CITY OF PORTLAND, MAINE  
PLANNING BOARD

December 18, 2013

Project Name: Studios at 46 Market Street  
Address: 46 Market Street  
Applicant: Market Milk Partners, LLC

Project ID: 2013-245  
CBL: 32-E-10001  
Planner: Nell Donaldson

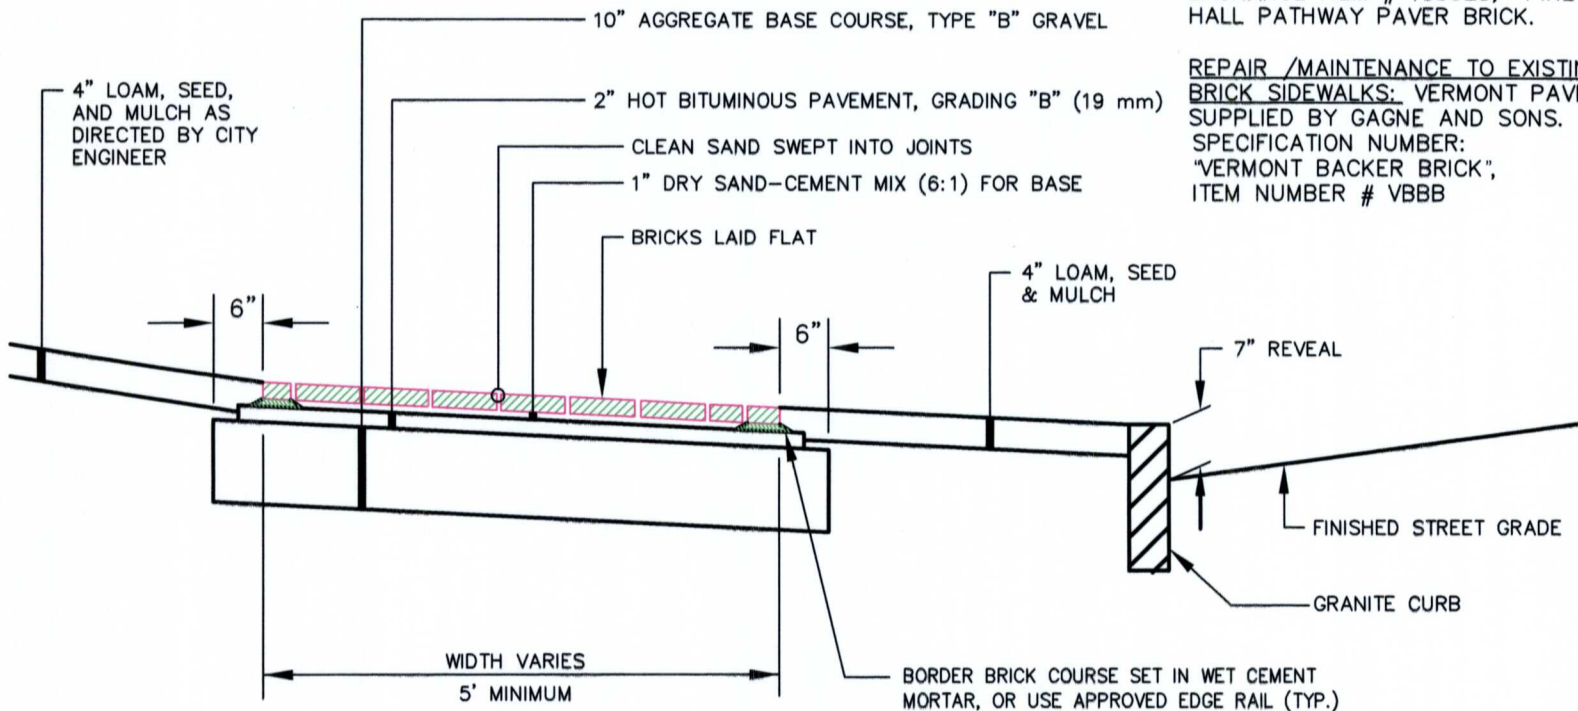
2. The applicant shall provide plans, stamped by a licensed engineer and including details, depicting:
  - a. the reconstruction of the ramp at Milk and Market Streets to include a standard detectable warning panel and flush granite curb, and

- b. the reconstruction of areas of sidewalk on Market Street to eliminate tripping hazards for review and approval by the city's Department of Public Services and Planning Authority;
